Re: [External] 1363 Washington Ave Portland - Taco Bell - 2016-007

The city was and is concerned about safety at this location as it is a route to school and already a high crash location.

The city's Traffic Engineer (Tom Errico of T Y Lin) initially recommended denial of the application based on the access situation, so the conditions of approval are quite important. He does not consider that the *Crash Study* supports leaving the status quo for the Taco Bell access (with no restrictions), and these were the comments recently sent to Kyle and Dave:

EASEMENT AREA

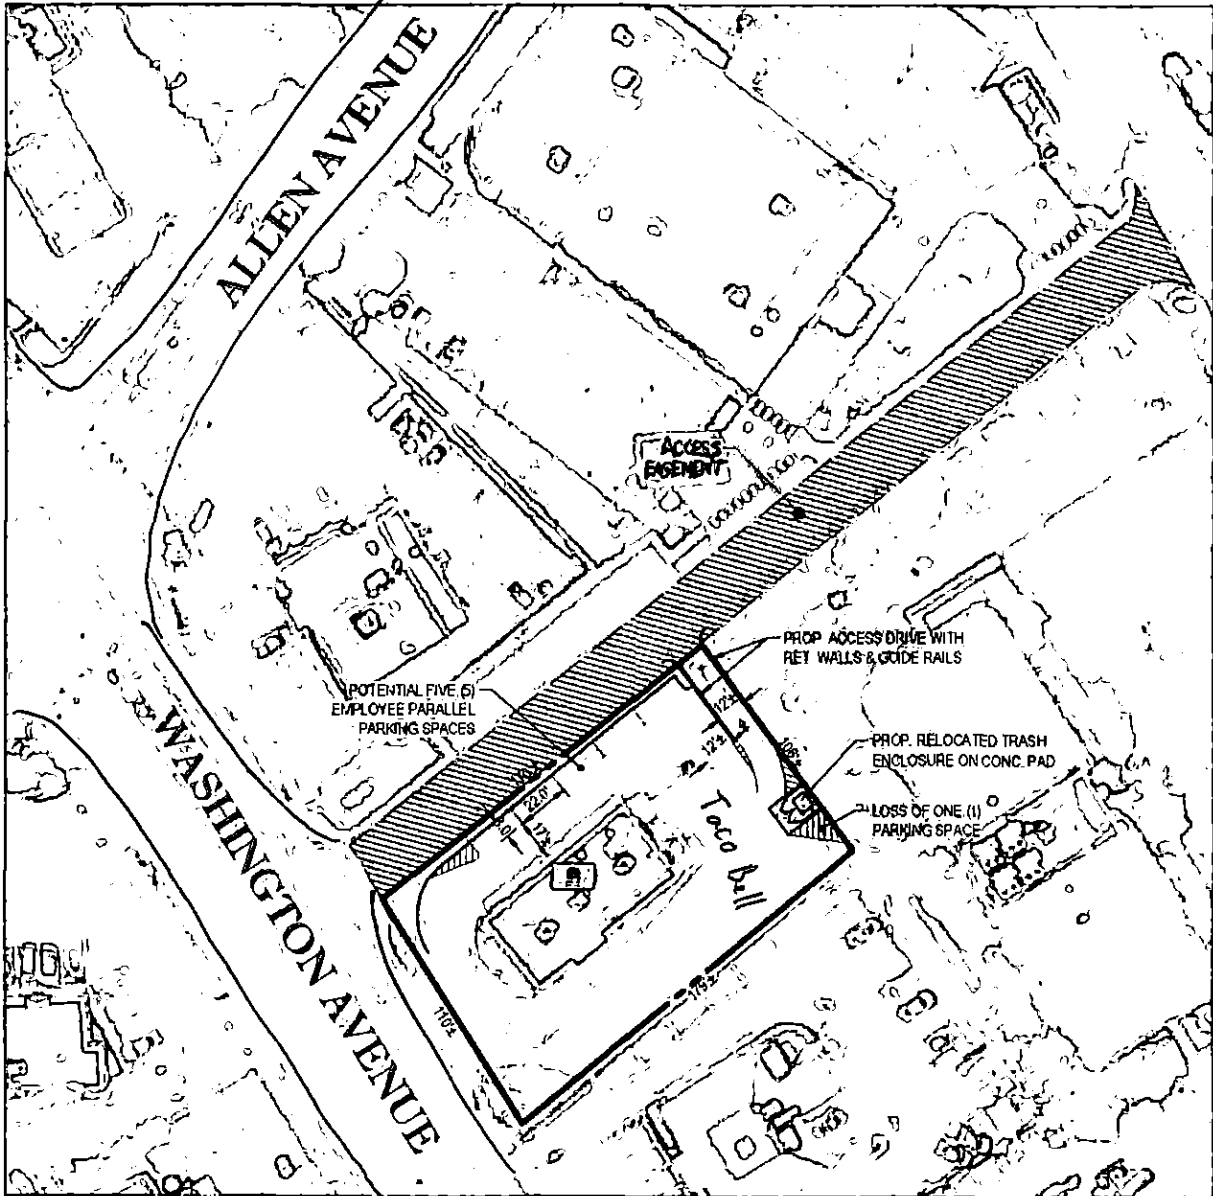
He also noted that the abutting Rite Aid building (with driveway) is now empty and strongly recommends that Taco Bell take advantage of the opportunity for joint access arrangements that would remove some of the turning movements on Washington Ave. It could be that the difficulty of access (and concerns by potential customers of having a crash) deters potential customers, so this might help business there.

If the access link between Taco Bell and the Rite Aid drive were implemented in the near future, these restrictions would not be required. All of the city engineers feel the connection to the Rite Aid drive is the best solution and strongly encourage this to be pursued now.

**C-2**

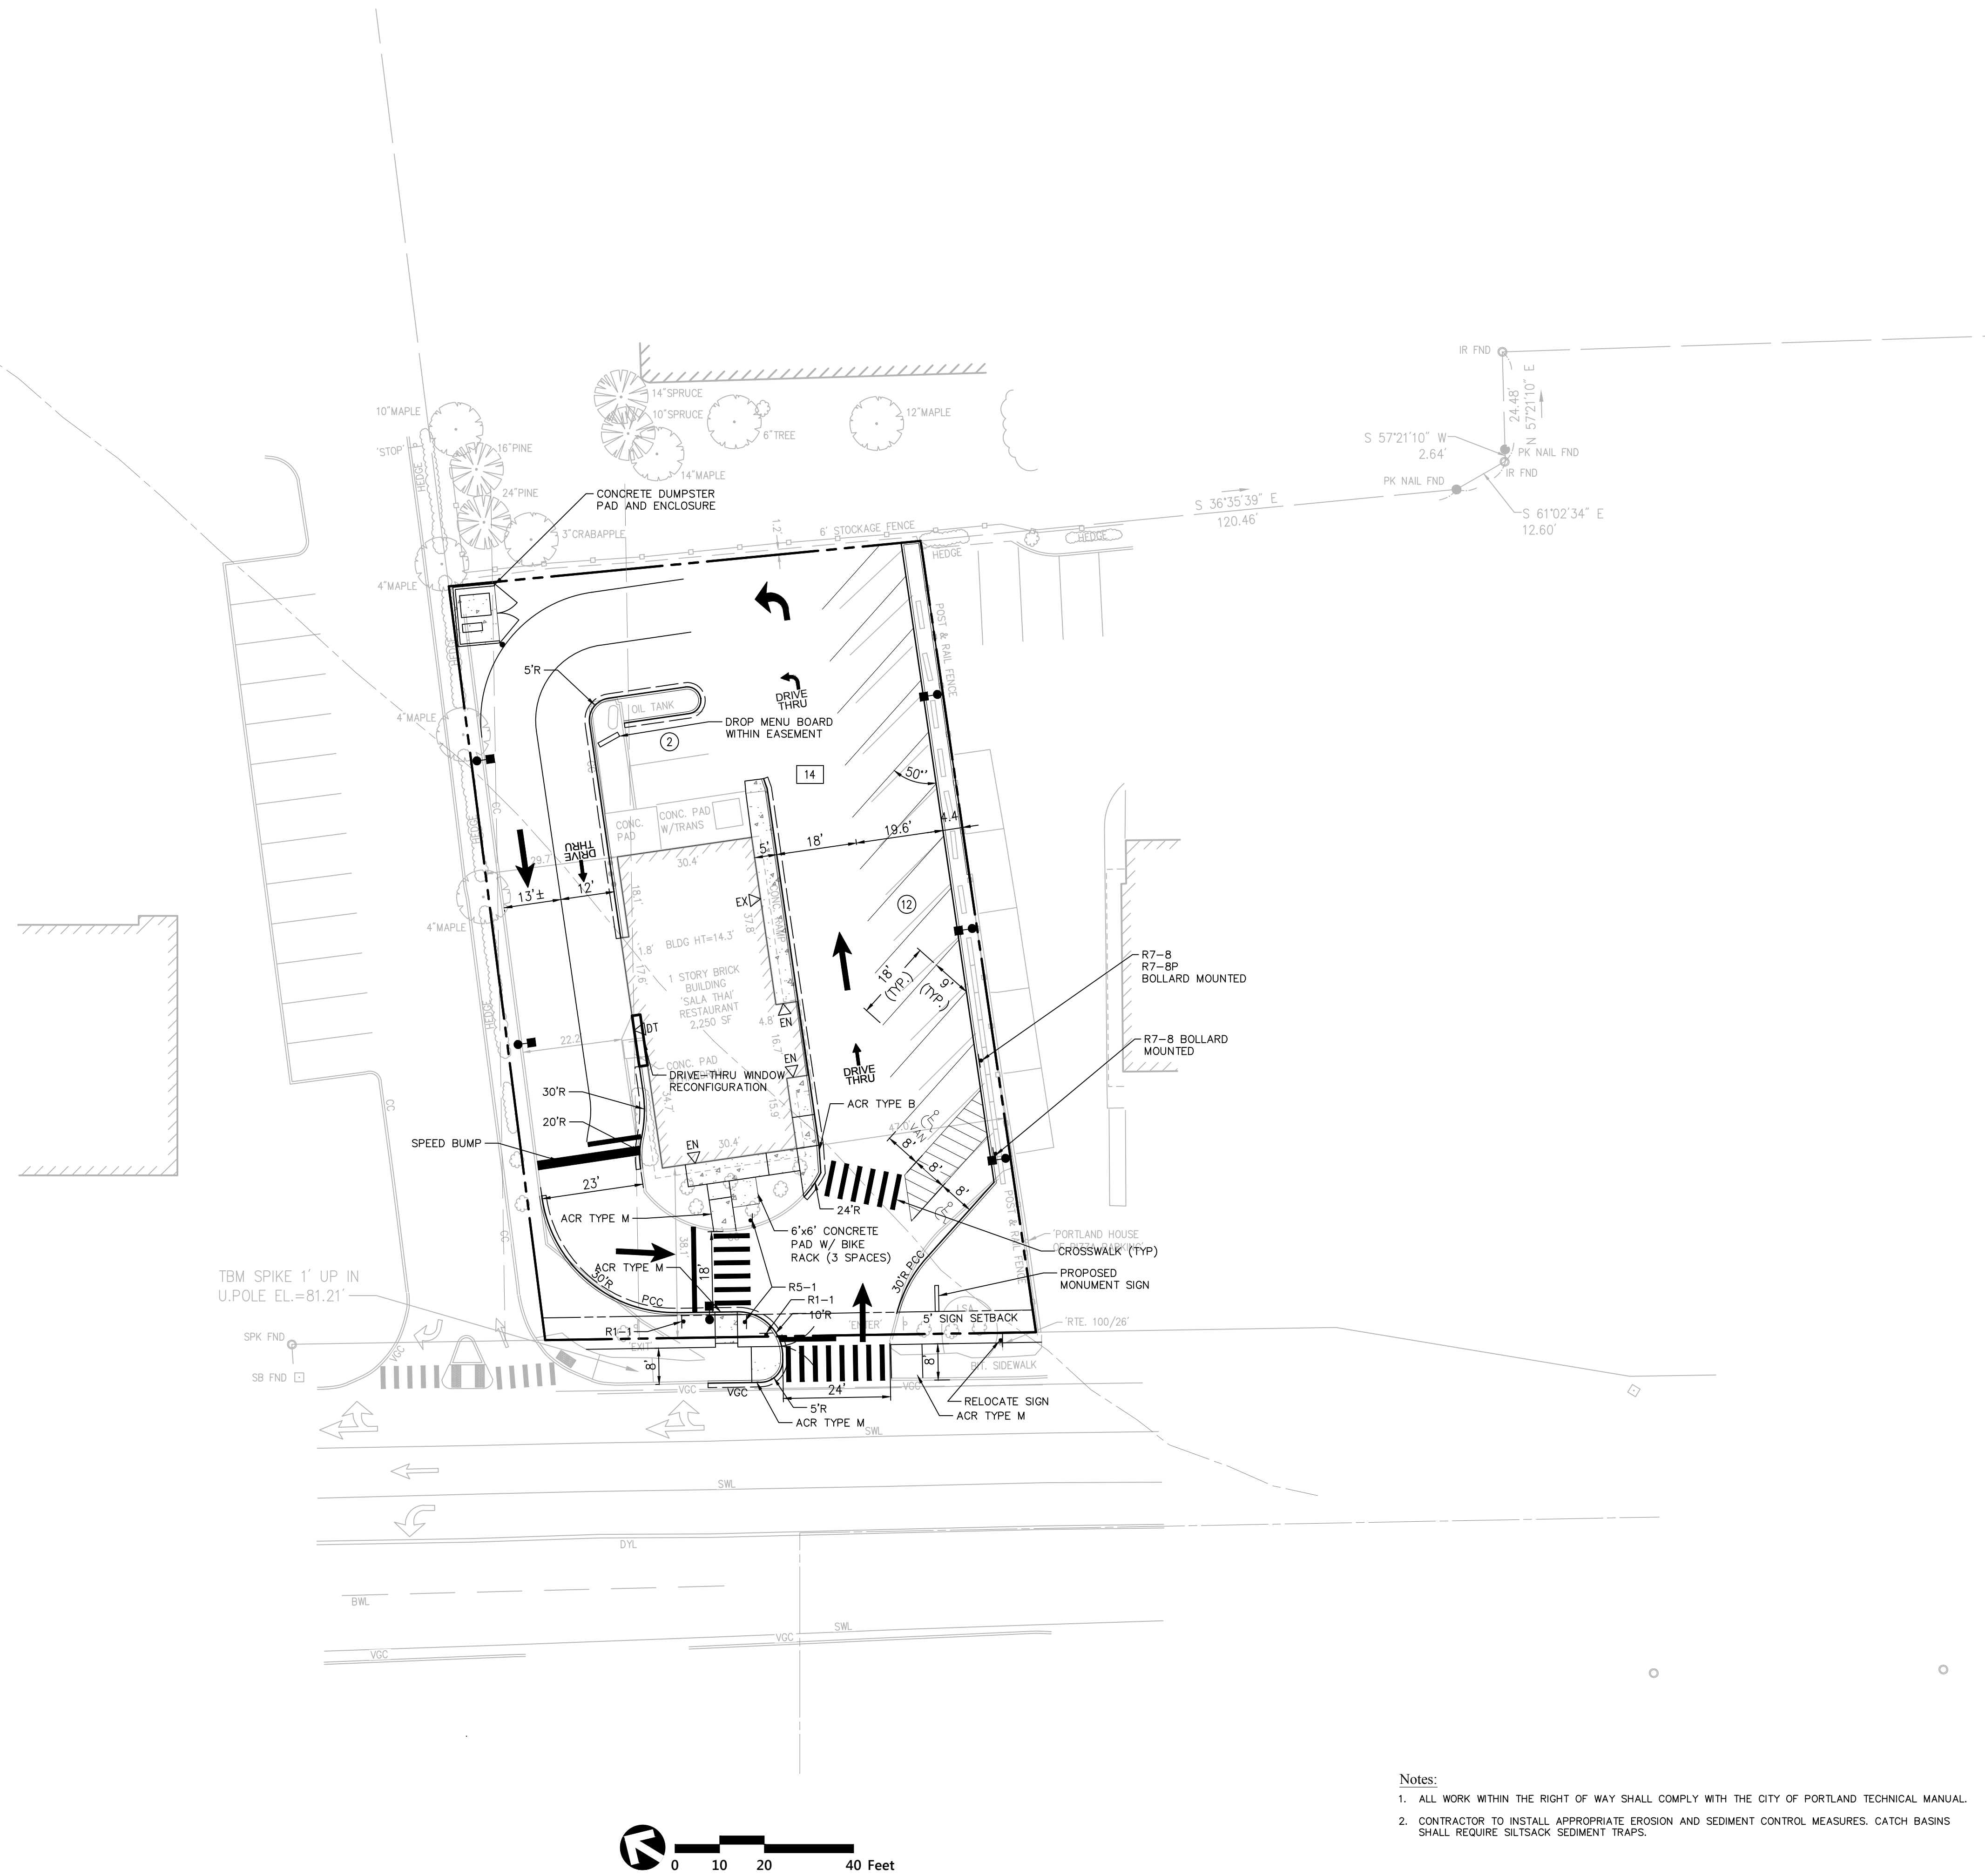
- *That based on the data, the implementation of a right in/right out only restriction appears to be warranted;*
- *That the absence of crashes in the spring may be because of a seasonal aspect, or related to changes in the total number of trips into/out of Taco Bell, so it is not necessarily indicative of a trend;*
- *That in view of Kyle's comment that business was less than expected during this first year, the crash rate may be related to that - and if business improves there may be more crashes.*

In this case the restriction would be a center median in the Washington Avenue ROW that prevents left in and left out movements from Taco Bell. Due to weather this might not be able to be implemented immediately, so the interim restriction would be signage stating no left out and no left in.
